Application Reference Number:		2024/1040	
Application Type:		Householder	
Proposal Description:		Single storey rear extension with wraparound to side elevations	
Location:		Cherry Tree House, 57 Hay Green Lane, Birdwell, Barnsley, S70 5XA	
Applicant:		Dr Lyn Sutcliffe	
Third-party representations:	Four from 2 no. addresses	Parish:	None
		Ward:	Rockingham

This planning application seeks householder planning permission for the erection of a flat roofed single storey rear extension to the dwelling with wraparound to the side elevations. The application was amended from an initially proposed two storey rear extension also coving the full width of the dwelling with a flat roof and proposed terrace.

scale: 1:50/100	job agent KC	drawn KC	checked
date 30-06-25	project no. 2426	drawing no. 002	revision G

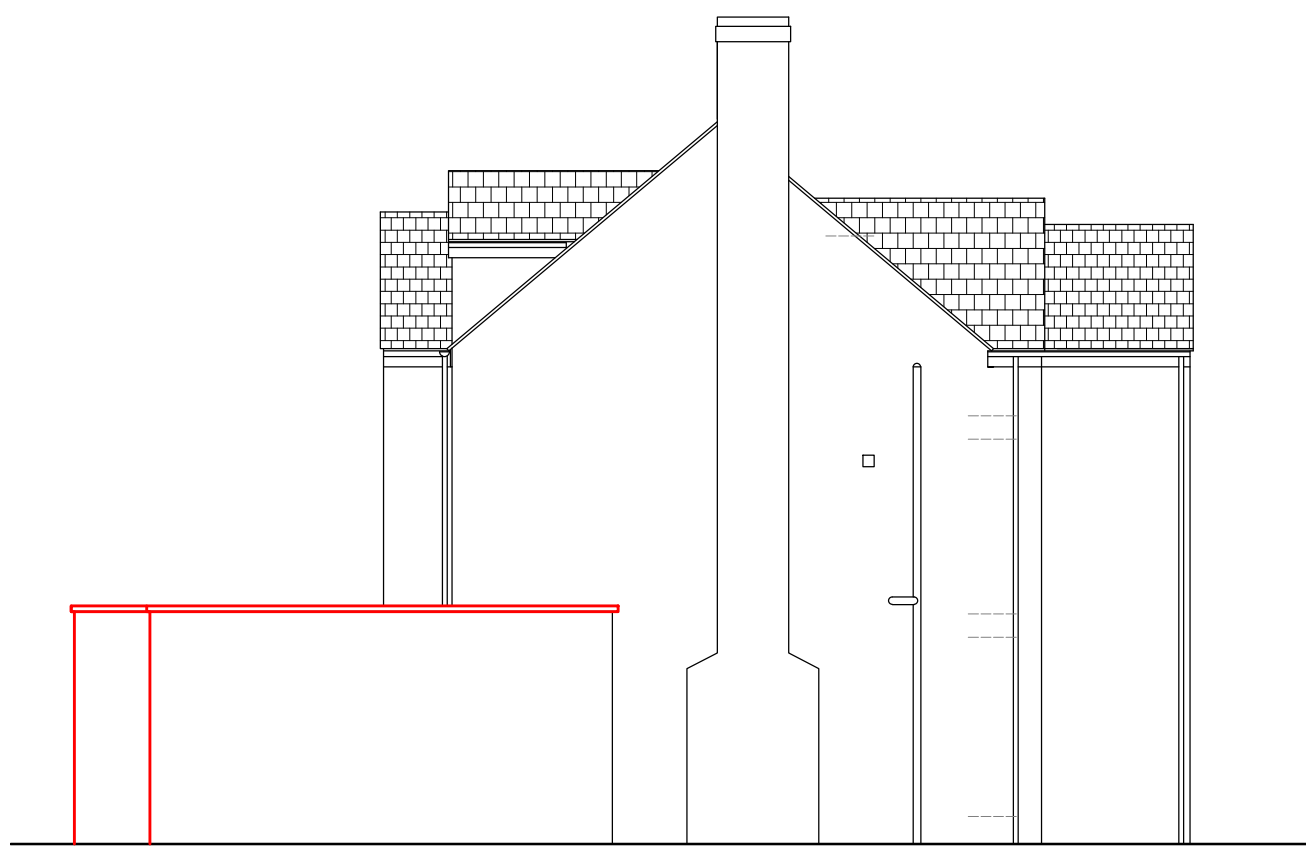
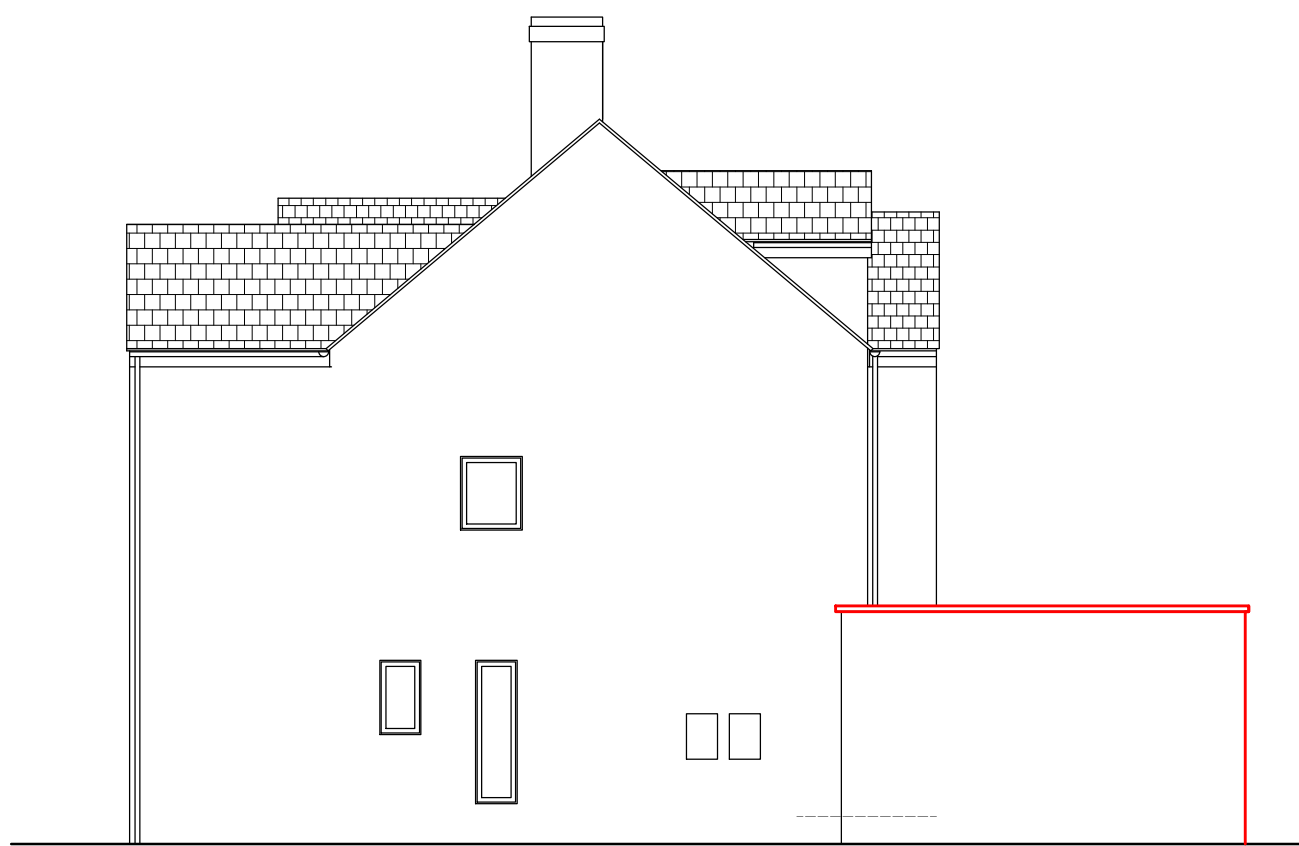
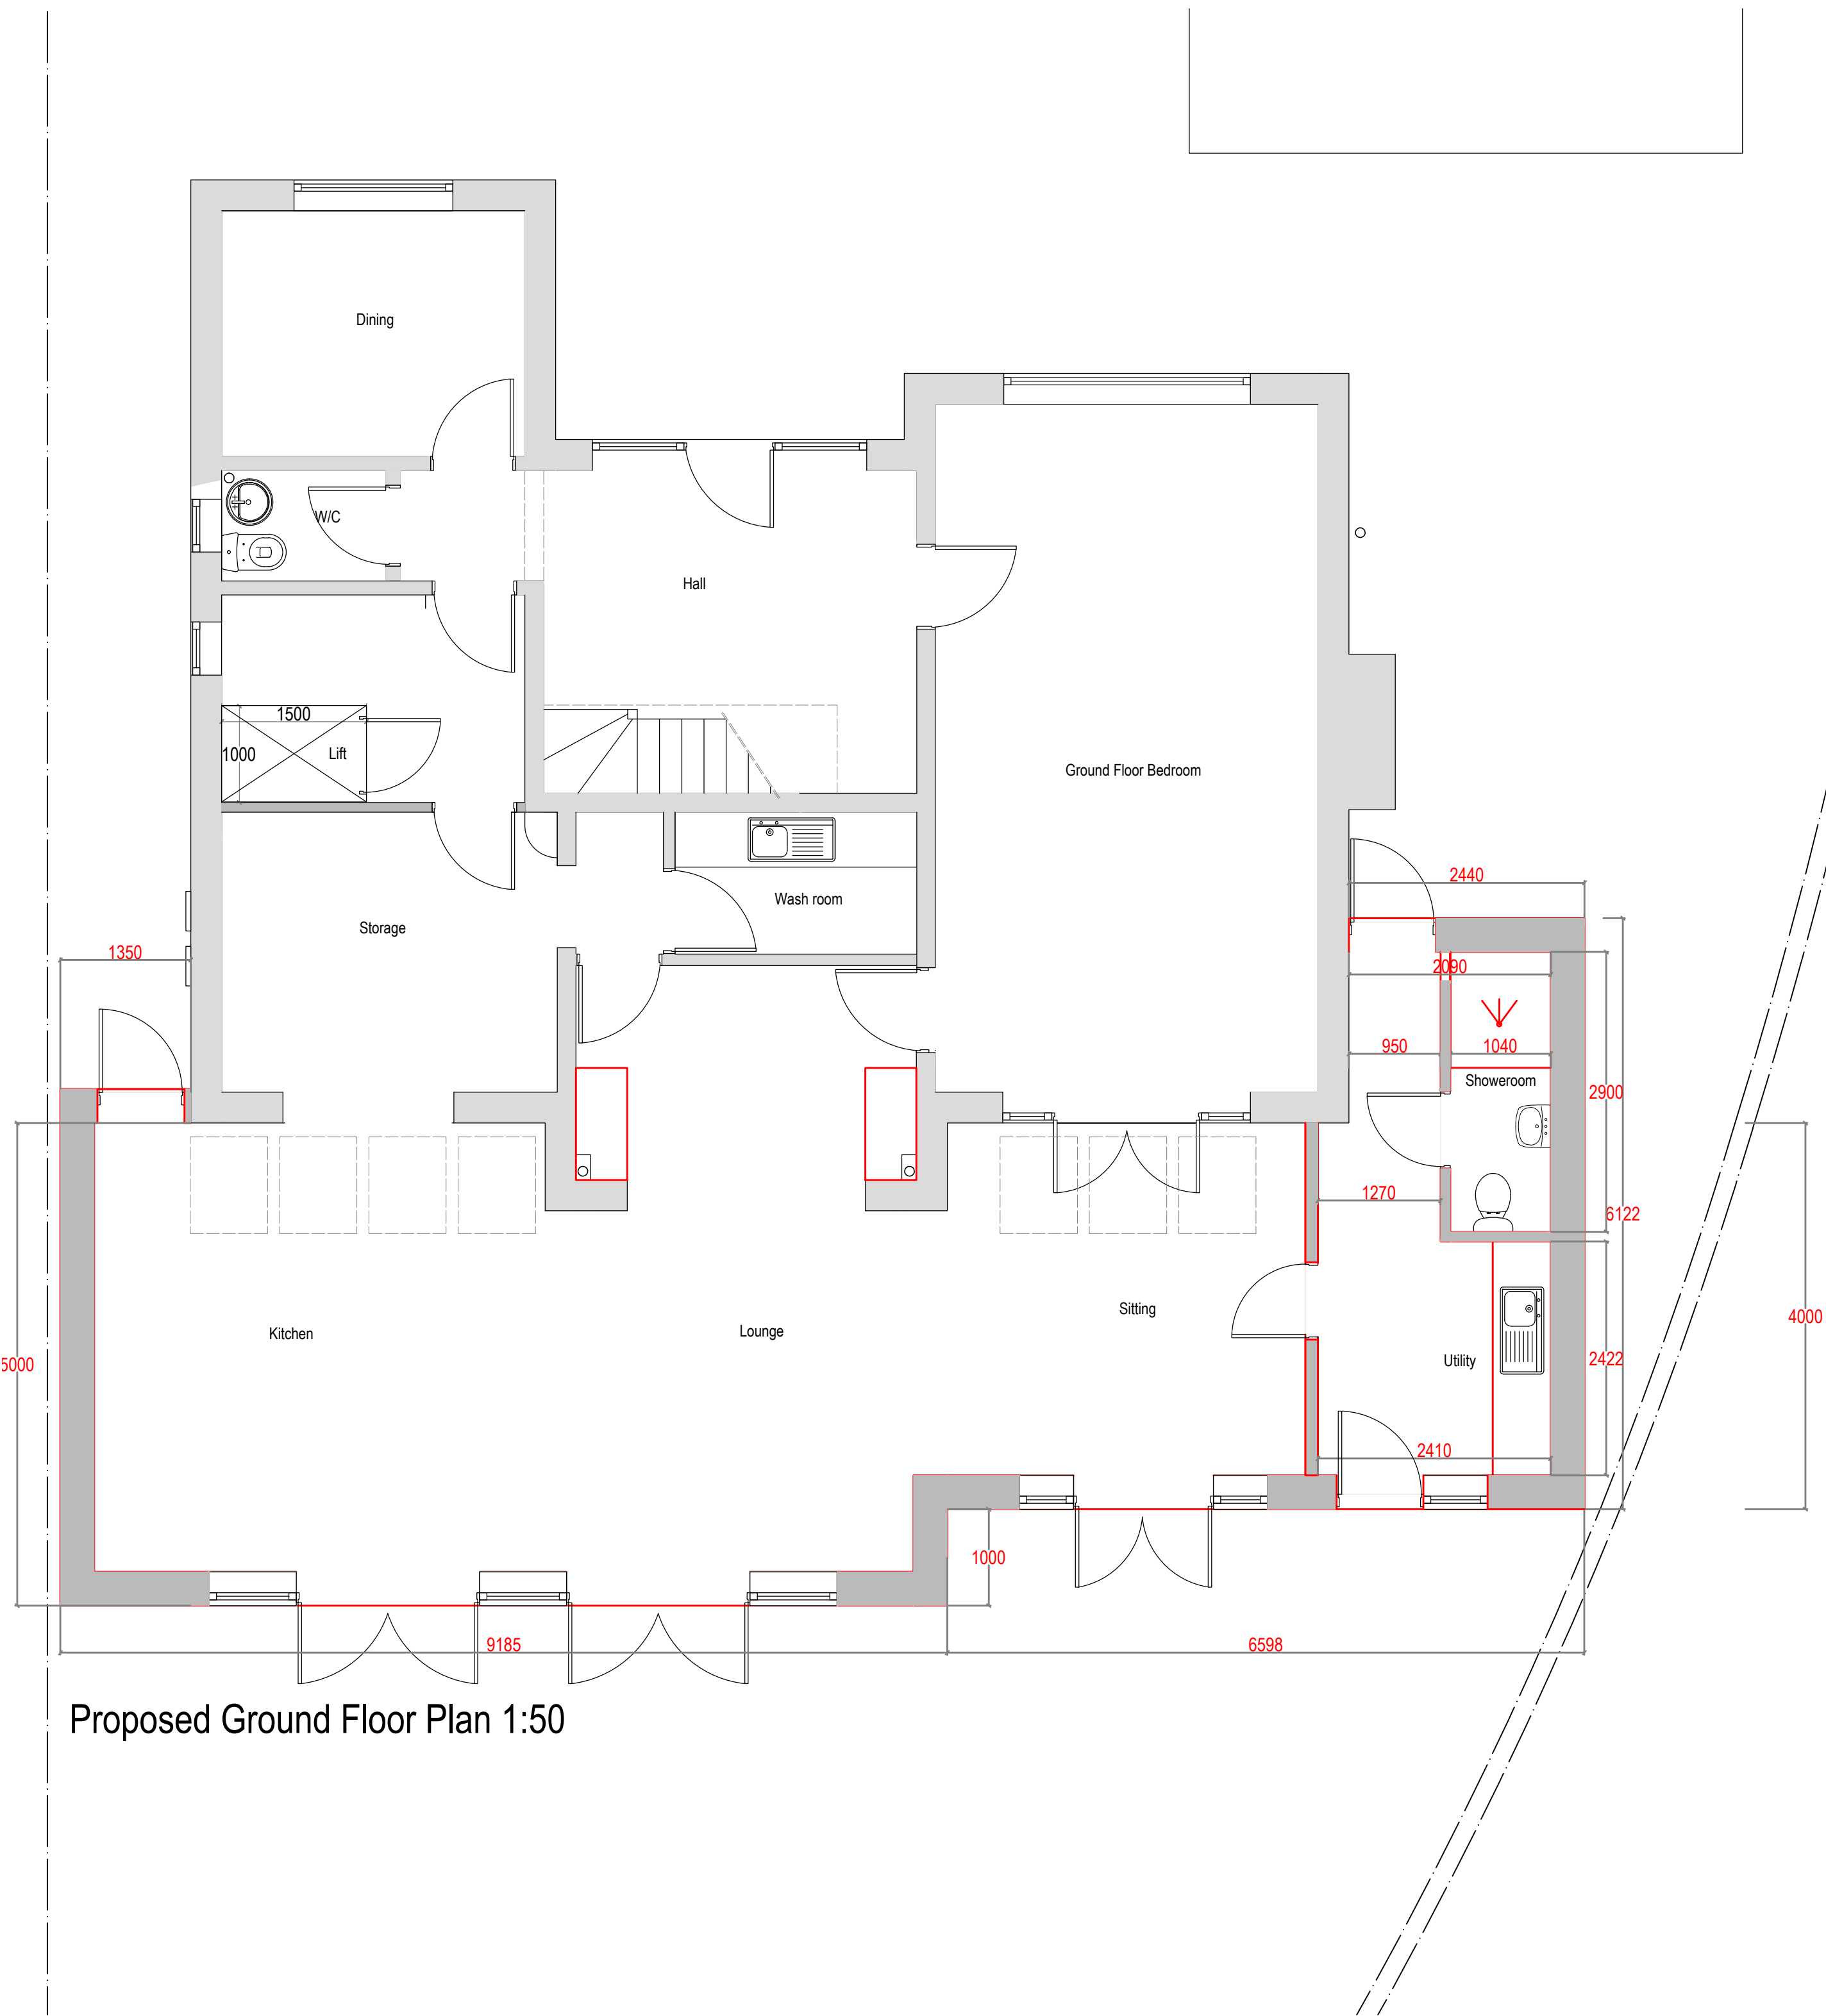
The SPD states that *“extensions to the rear of detached houses will be considered on their design merits and where no adjacent properties are affected”*. The design is relatively in keeping with the existing dwelling and the extension has a maximum rear projection of 5.05 metres. The side projections are modest and significantly less than two thirds the width of the existing dwelling.

Whilst objections were raised in relation to overlooking, overbearing and loss of sunlight and privacy, the proposed extension would not have a significant detrimental impact on any neighbouring property due to its appropriate proportions and modest projections which are deemed acceptable for this large, detached dwelling which is compliant with the adopted spd. The extension is not considered to be of an excessive size or scale and is an extension of the existing building form rather than a separate, stand-alone addition and is therefore subservient to the existing dwelling. Equally, it is not considered overbearing due to its restrained size and massing especially in relation to the initial proposal which was of two storeys. This weighs significantly in favour of the proposal.

As the extension is only of single storey, overlooking will be limited even with the addition of patio doors to the rear elevation, as they predominantly look onto the host dwelling's garden area. It is acknowledged that introduction of these could potentially increase levels of overlooking over the existing of the neighbouring dwellings, however with the existing tall fence providing adequate boundary treatment it is considered that the levels would not be harmful. This weighs modestly in favour of the proposal. The proposal is considered to be in compliance with Local Plan Policy GD1: General Development and is acceptable in terms of residential amenity.

The SPD states that *‘materials should normally be of the same type, colour and texture to the existing house or as close a match as possible’*. In this case, the proposed materials will match the existing dwelling with matching stonework to be used. The proposed roofing materials whilst not matching

The extension utilises a flat roof which is normally accepted as it can be an inferior form of construction. However, the extension is of a modern orangery style and is set to the rear of the property. A flat roof rear extension is already present to the rear of a neighbouring property (55 Hay Green Lane) which is also visible from the properties to the south and would therefore not impact additionally to a significant degree on the character of the area. As the extensions would only very slightly extend beyond the side elevations its impact on the existing streetscene would be very minor. This weighs moderately in favour of the proposal.

- Alterations to extension reducing height by reducing the proposal from two stories to a single storey and omitting the terrace
